Our ref: DOC19-319312

Subject: Howlong Sand and Gravel Quarry Expansion (SSD 8804) - Review of Environmental Impact Statement

ATTACHMENT A – BCD assessment summary for Howlong Sand and Gravel Quarry Expansion (SSD 8804) - Review of Environmental Impact Statement

**FIGURE 1-3 SITE LAYOUT**

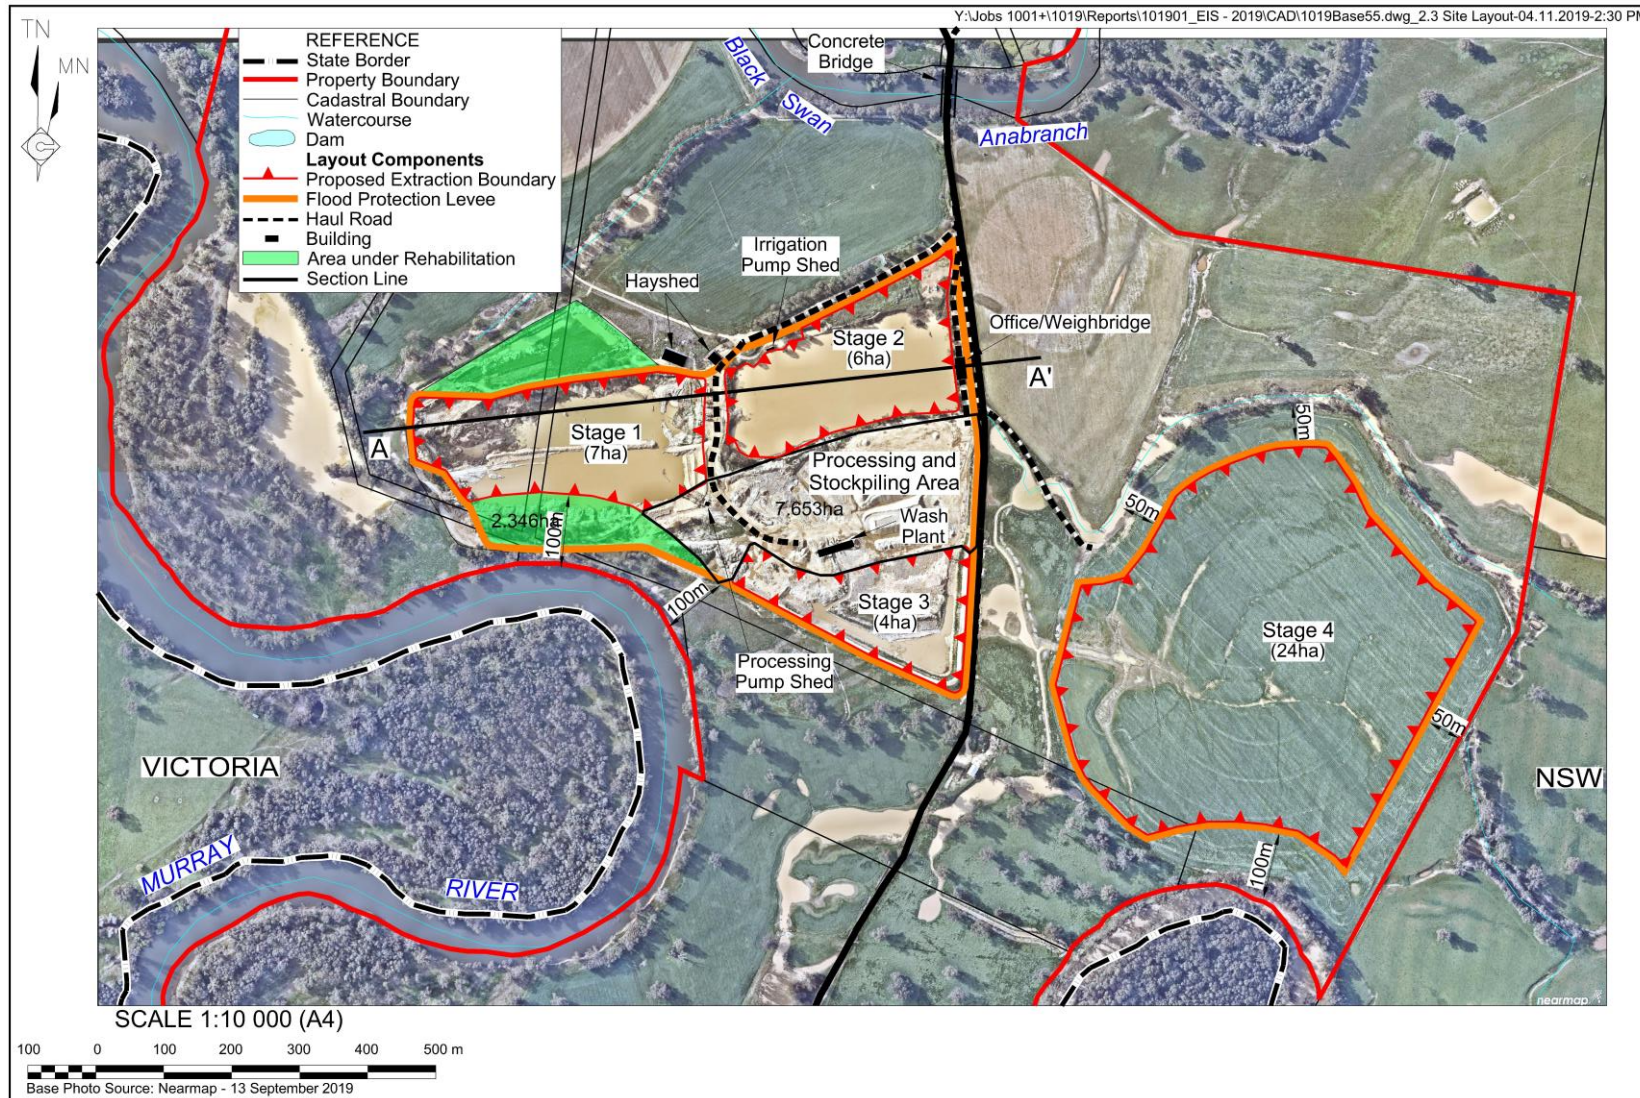
Although the impacts of the proposed levee developments around the extraction pits have been assessed on a global scale with adverse affluxes of up to 0.3m expected immediately upstream of the development in the 1% Annual Exceedance Probability (AEP) flood, the effect on the various properties, assets and infrastructure within this impacted zone have not been specifically assessed. We note that the impacts extend some four kilometres upstream.

This more detailed assessment would allow for the determination of whether the proposed 1% AEP levee system would result in affluxes that would be prejudicial to these upstream properties, assets and infrastructure. It would also allow for the assessment of impacts on any flood evacuation routes to be determined.

A more detailed and targeted impact assessment is required to effectively determine the level of flood impact on upstream properties, assets and infrastructure caused by the proposed levee development.

**FIGURE 5-3 DIFFERENCE MAP – 1% AEP FLOOD EVENT**

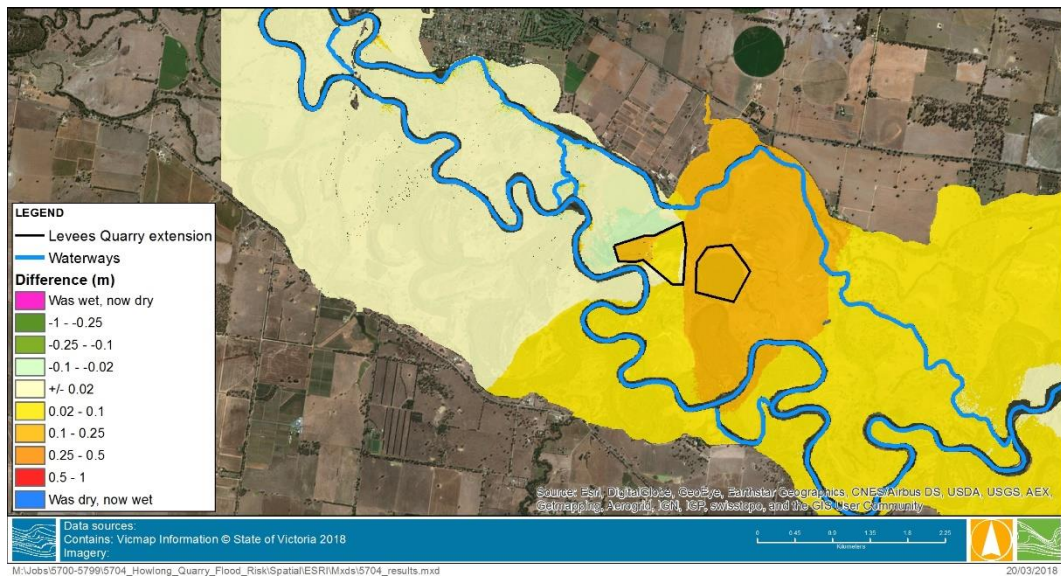
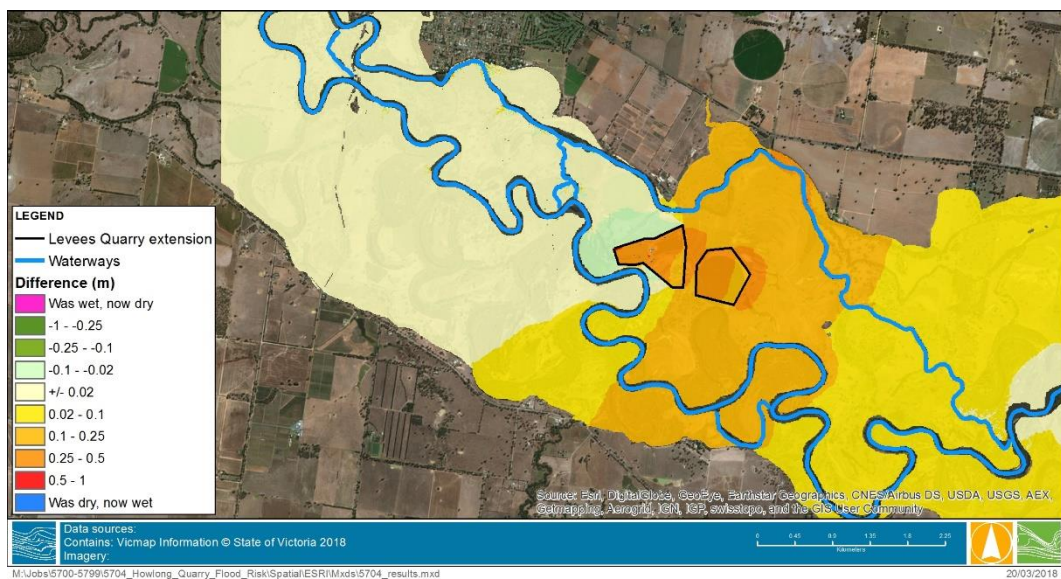
With this level of assessment, it is not possible to determine the degree of impact on these upstream receptors (primarily levels of afflux but also flow, velocity and hazard) and whether the impact is in fact prejudicial.

The SEARs (13a) specifically required the determination and assessment of any detrimental increases in the potential flood effect on properties, assets and infrastructure. We do not consider that has been successfully completed in this case.
